Our Ref: TR020001

Date: 27 March 2023

Application by London Luton Airport Limited for an Order Granting Development Consent for the London Luton Airport Expansion project

Advice following issue of decision to accept the application for examination

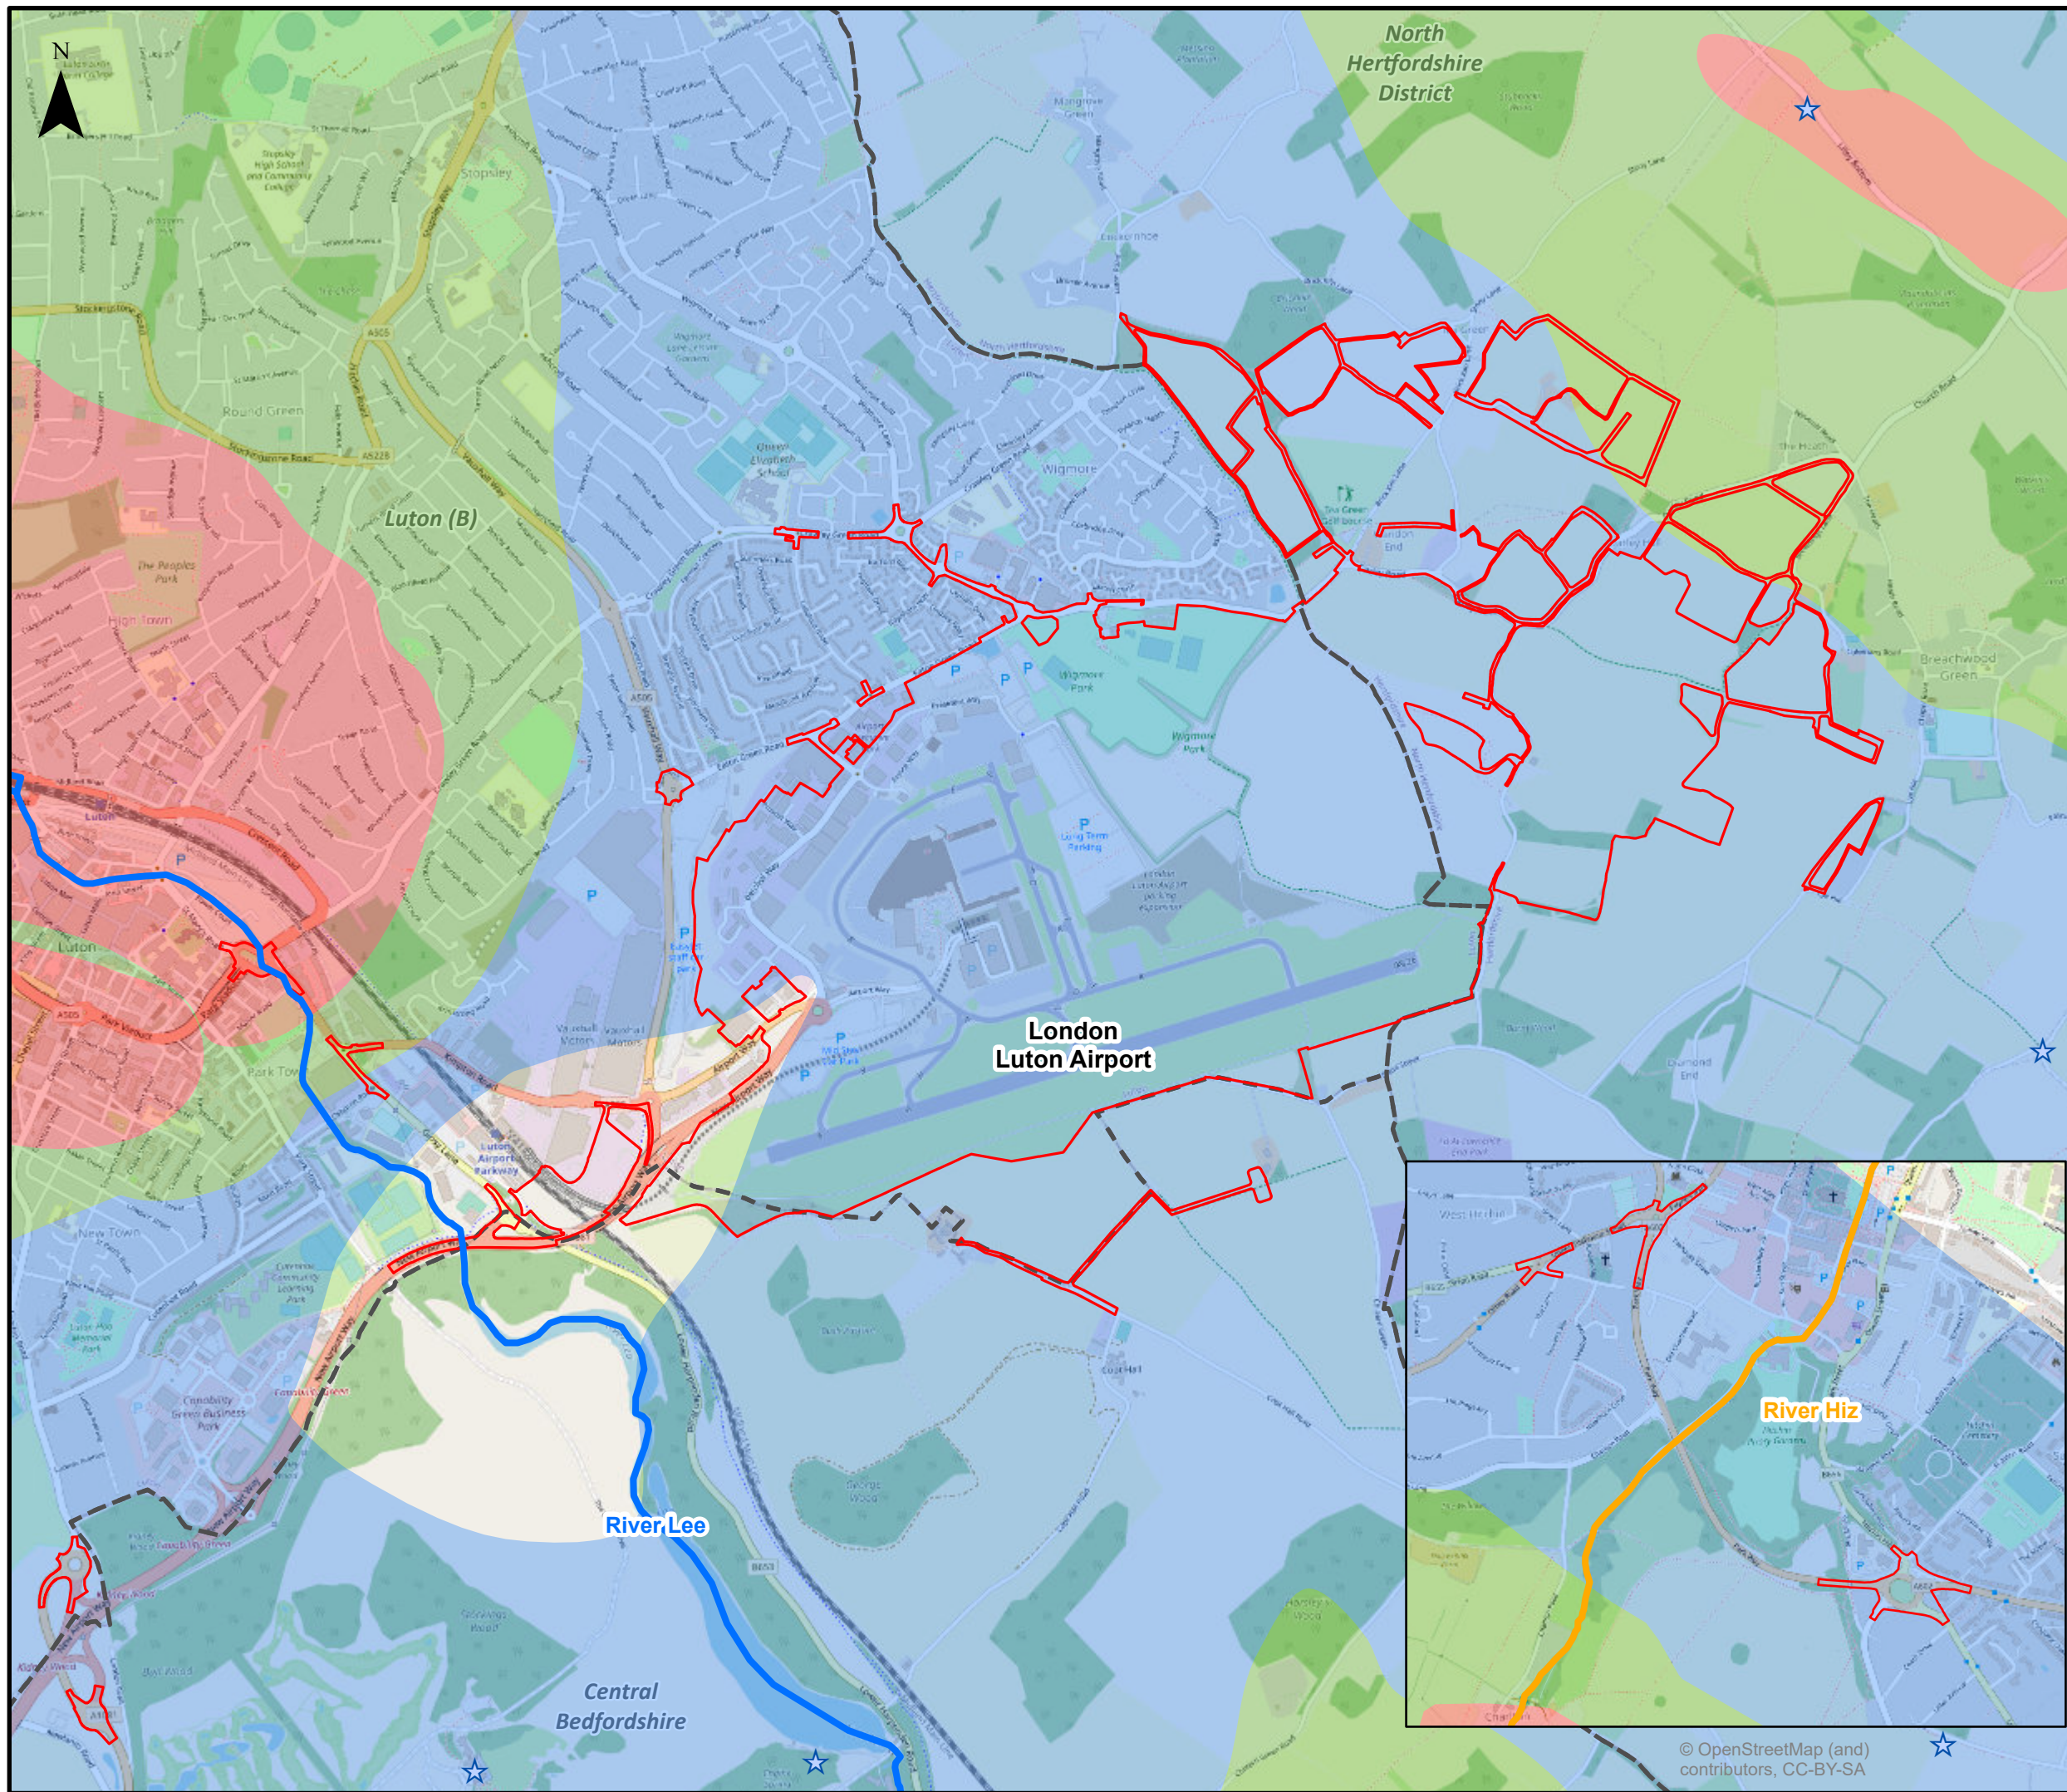
In figure 20.2 (5.03 Chapter 20 (water resources and flood risk figures 20.1- 20.6) private water abstractions are shown as blue stars on a largely blue background. Consequently, they are difficult to identify. Table 20.11 of chapter 20 of the ES also states that discharge consents are marked on Figure 20.2 but this figure does not show the location of any discharge consents. Discharge consents, springs and groundwater abstractions should be clearly illustrated on a plan.
